From: Peter Cleveland
Sent: 25 January 2011 16:46
To: 'Graham Clark'
Subject: RE: 044 - 102 The Splash - Wepham ref B/10/10/

Arun District Council
Arun Civic Centre
Maltravers Road
Littlehampton
West Sussex BN17 5LF
Planning & Building Control General Enquiries
Tel: (01903) 737756 Fax: (01903) 716019
Dx: 57406 Littlehampton
Minicom: 01903 732765
e-mail: planning@arun.gov.uk
website: www.arun.gov.uk/planning
Our Ref: B/2/11/
Your Ref:

Ground floor extension to living area at side and rear of property and garden summer house in rear garden.
102 The Splash Wepham

Drwg No.	rev.
44-SH	-
Scales:	Date:
1:100	04.04.10

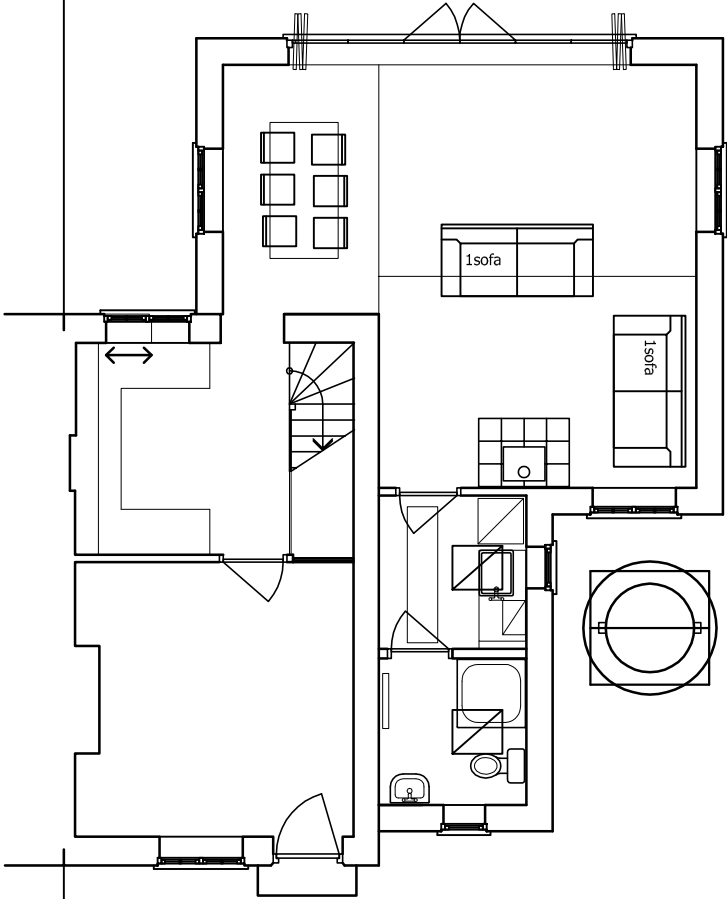
Drawing No. 44-SH should note that the plan identifies the existing summerhouse layout. Also if you have elevations for the proposed summerhouse this will also be required.

44-L

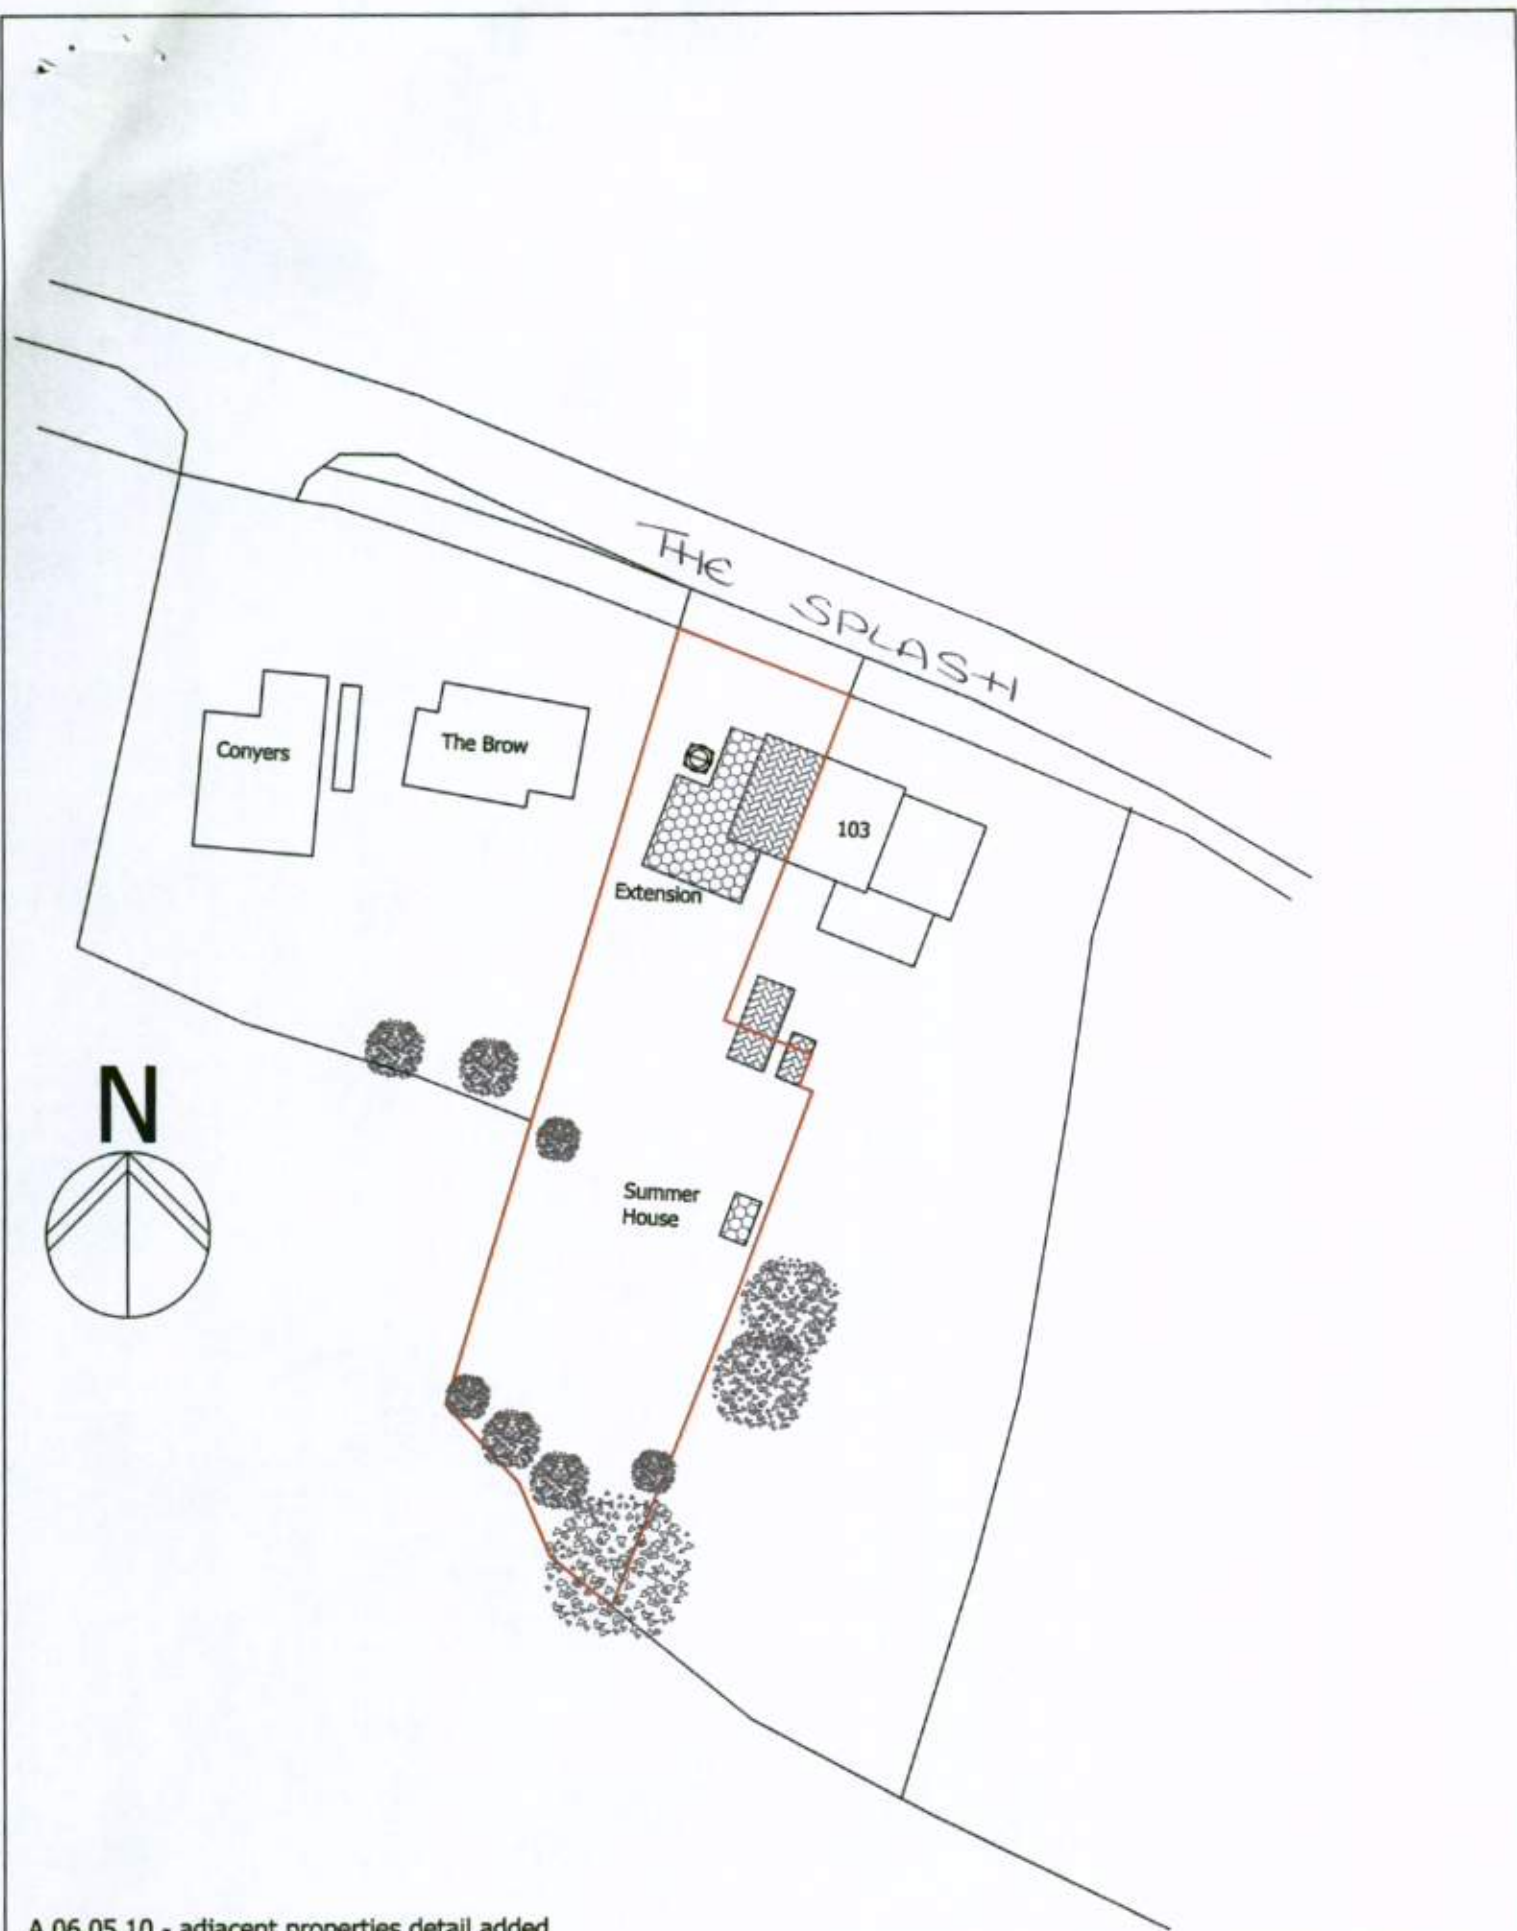
☒ I require 1 electronic or 3 paper copies of a revised block/site plan with one named road in accordance with the guidance notes available on our website detailed below (click on National List). *Still incorrect*

I require 1 electronic or 3 paper copies of a revised block/site plan with one named road in accordance with the guidance notes available on our website detailed below (click on National List).

Drwg No. 44-SHD	rev. -	Thomas & Susanne Jensen 102 Wepham No dimensions to be scaled from this drawing	Summerhouse Plan and Elevations ©	Start to Finish gb Ltd tel 01306 882230 07920 774480
Scales: 1:50	Date: 05.02.11

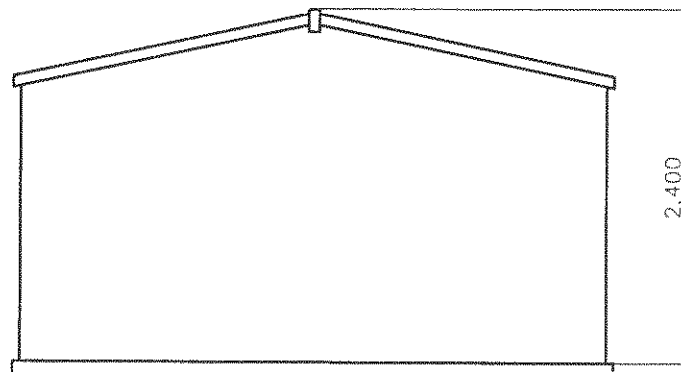
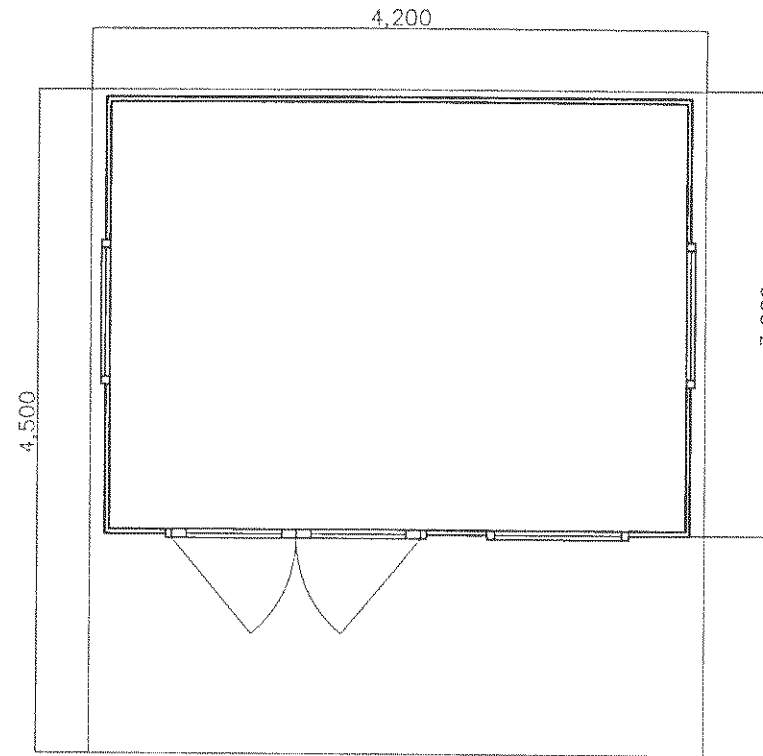
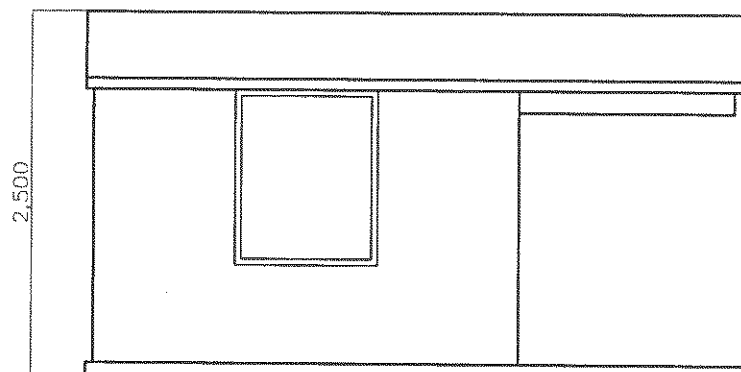
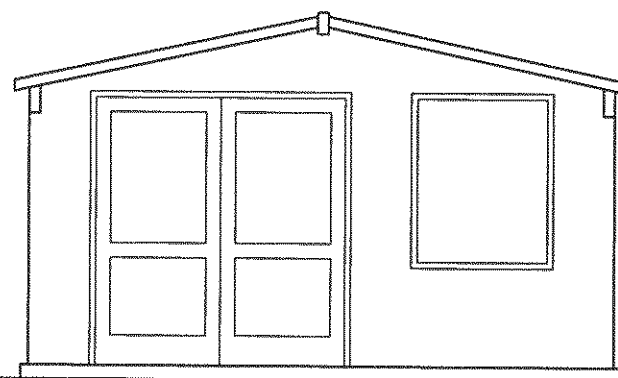
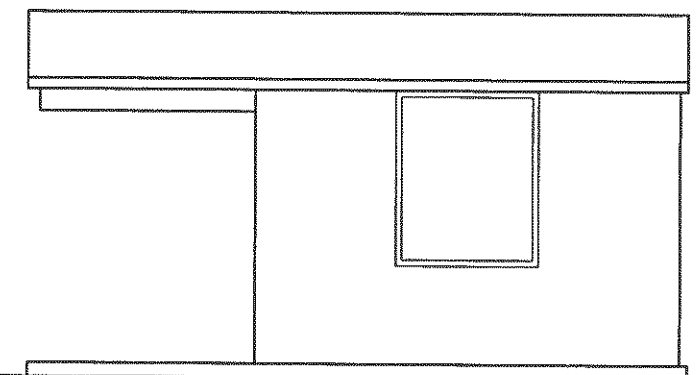
Please provide 1 electronic or 3 paper copies of existing and proposed elevations of the summer house in accordance with the guidance notes available on our website detailed below (click on National List). *Still need*

Please provide 1 electronic or 3 paper copies of existing and proposed elevations of the summer house in accordance with the guidance notes available on our website detailed below (click on National List).

As discussed last week please find attached the amended survey elevation drawing and the new drawing with a plan and elevations of the summerhouse. I hope this will now enable the application to be processed.

A 05.02.11 modified		rev. A		Thomas & Susanne Jensen 102 Wepham		Elevations Survey		Start to Finish gb Ltd	
Drwg No. 44-SE		Scales: 1:100		Date: 05.08.08		©		tel 01306 882230 07920 774480	
				No dimensions to be scaled from this drawing

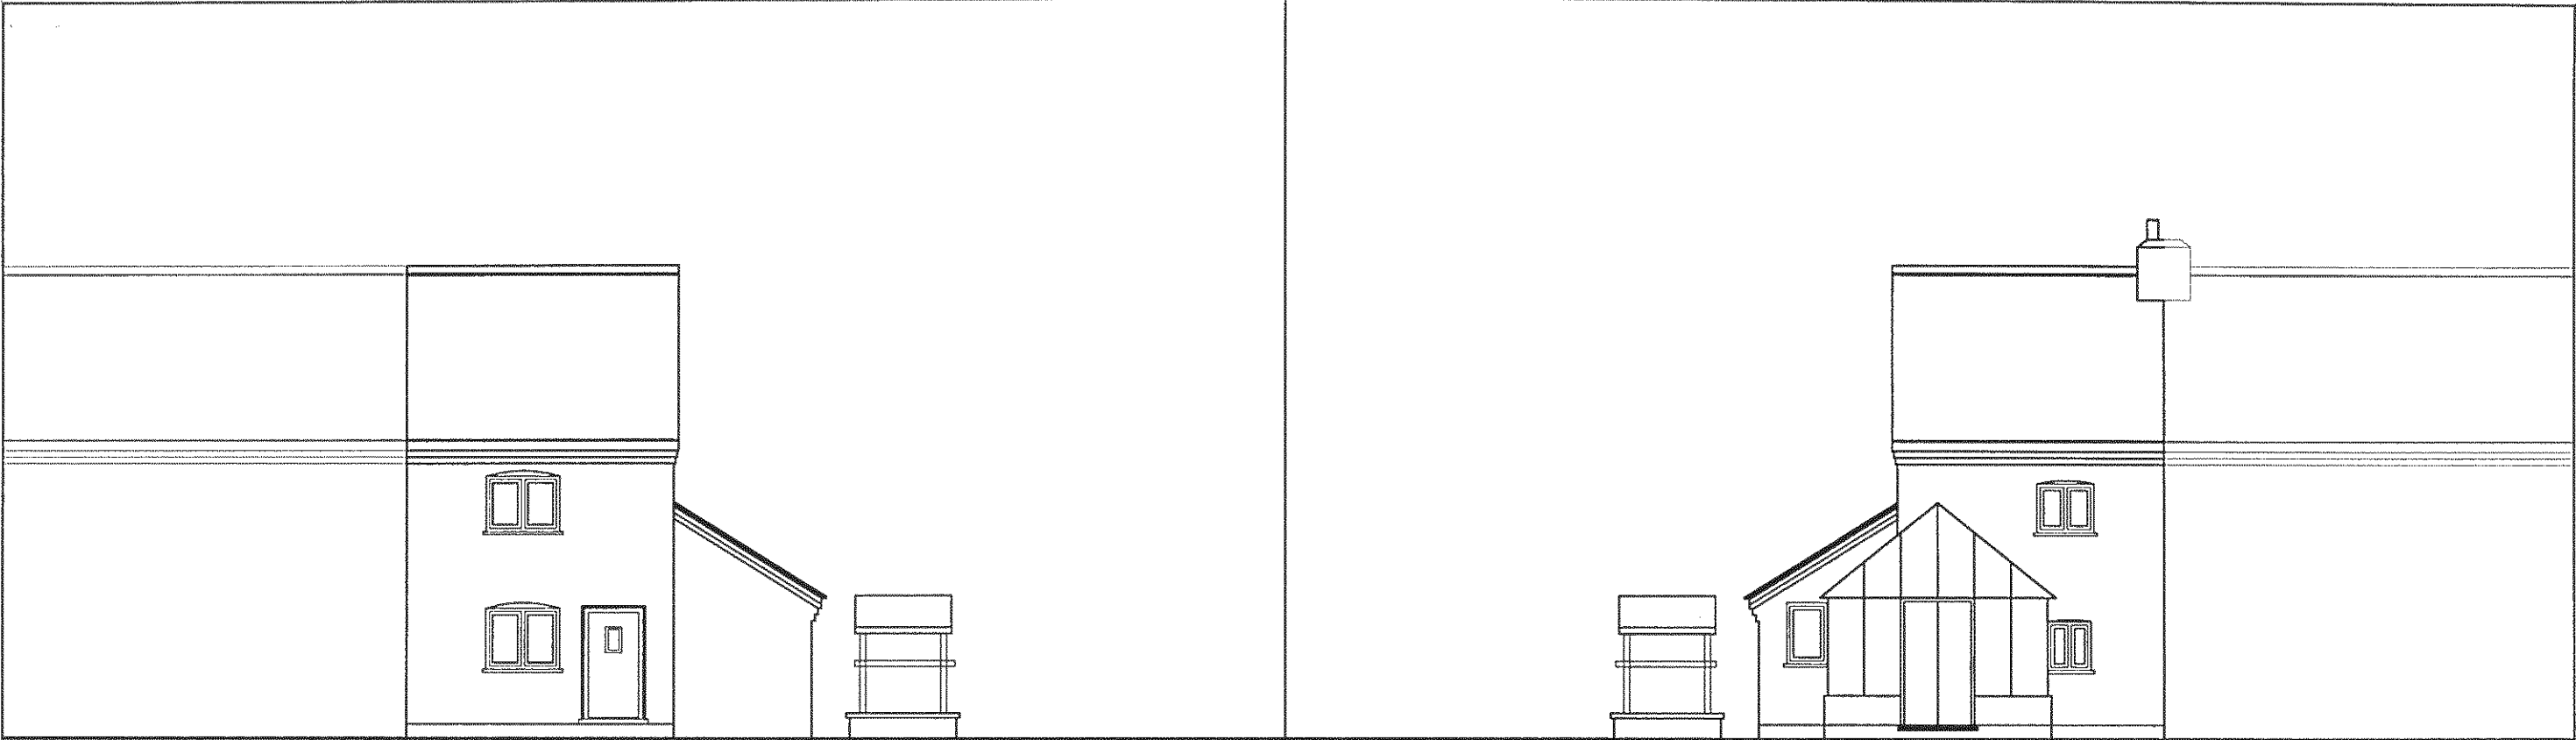
Please provide 1 electronic or 3 paper copies of revised existing rear elevations of the extension, as the bathroom window has been omitted from the plan, this is in accordance with the guidance notes available on our website detailed below (click on National List).
